Ribble Valley Borough Council
Council Offices, Church Walk
Clitheroe
BB7 2RA

Your ref: 3/2020/1085
Our ref: DC/21/122
Date: 26-JAN-21

Location: Land at Bank Cottages Whalley Road Billington BB7 9NL

Proposal: Proposed construction of two semi-detached bungalows with associated gardens and parking areas

Drawing Title
 Proposed Site Plan

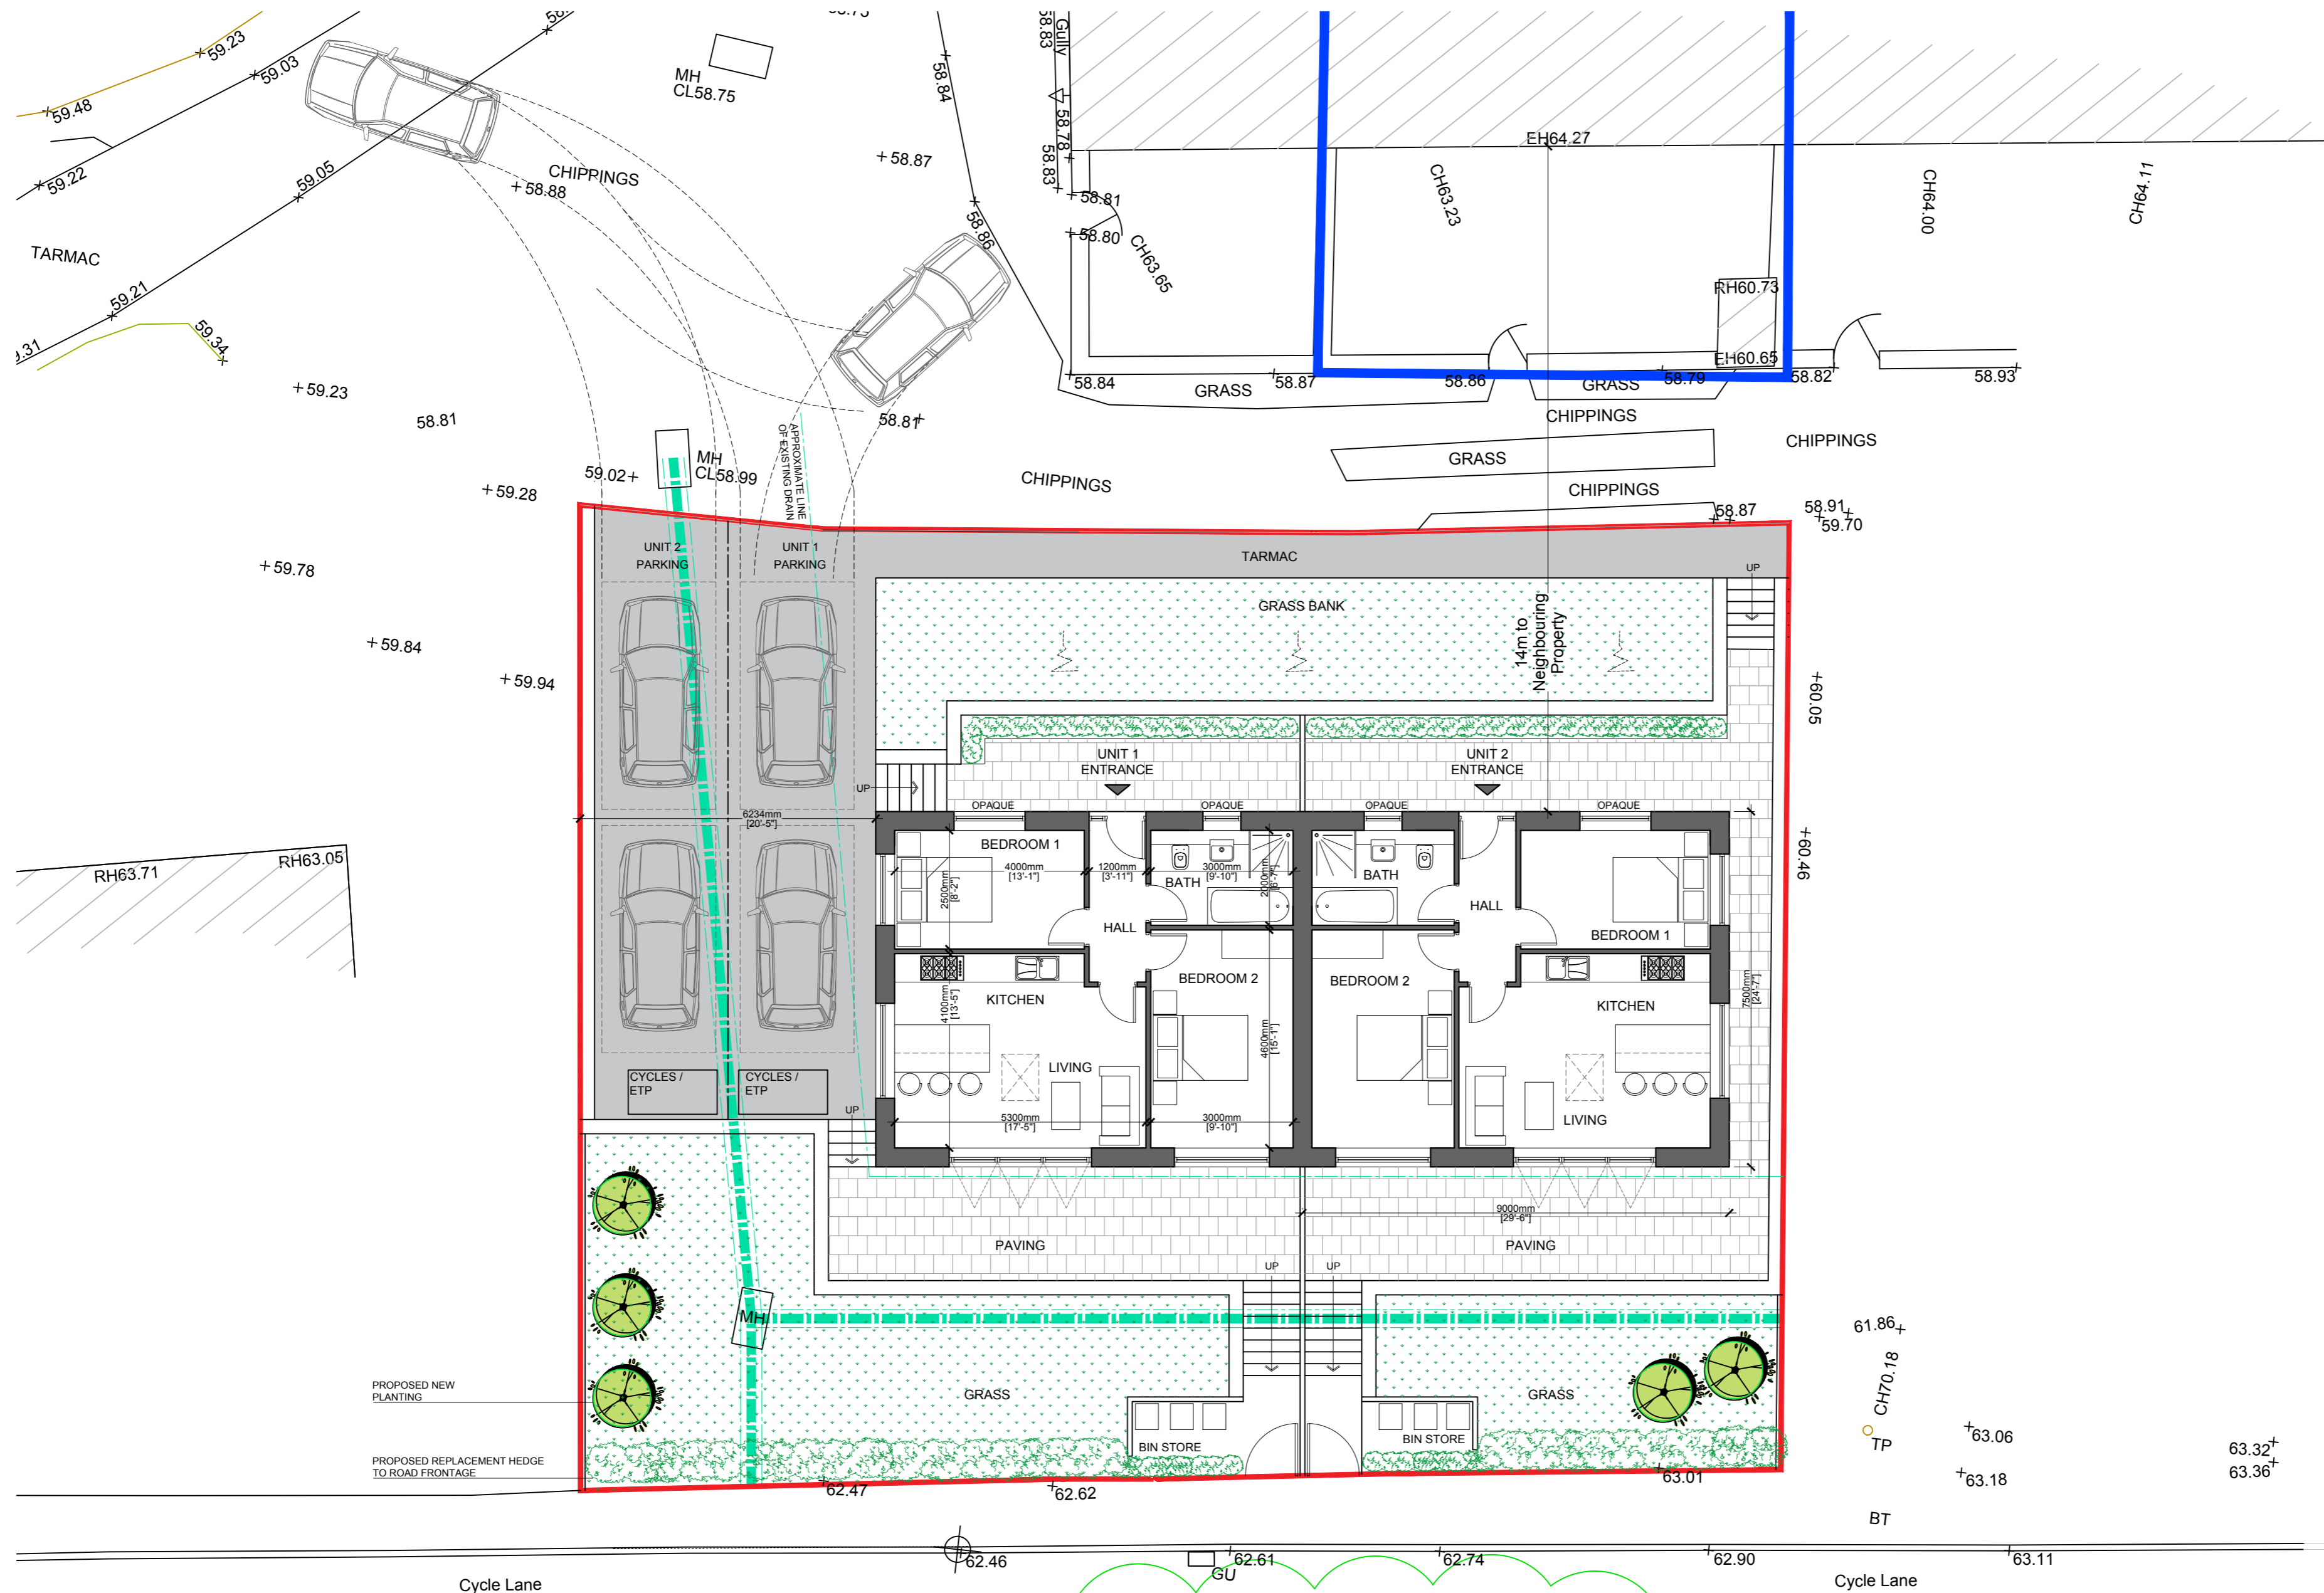
A water main crosses the site. As we need unrestricted access for operating and maintaining it, we will not permit development over or in close proximity to the main. We require an access strip as detailed in our 'Standard Conditions for Works Adjacent to Pipelines', a copy of which is enclosed.

The applicant must comply with our 'Standard Conditions' document. This should be taken into account in the final site layout, or a diversion may be necessary. Unless there is specific provision within the title of the property or an associated easement, any necessary disconnection or diversion required as a result of any development will be at the applicant's expense. If considering a water mains diversion, the applicant should contact United Utilities at their earliest opportunity as they may find that the cost of mains diversion is prohibitive in the context of their development scheme.

A public sewer crosses this site and we may not permit building over it. We will require an access strip width of six metres, three metres either side of the centre line of the sewer which is

in accordance with the minimum distances specified in the current issue of Part H of the Building Regulations, for maintenance or replacement. Therefore a modification of the site layout, or a diversion of the affected public sewer may be necessary. All costs associated with sewer diversions must be borne by the applicant.
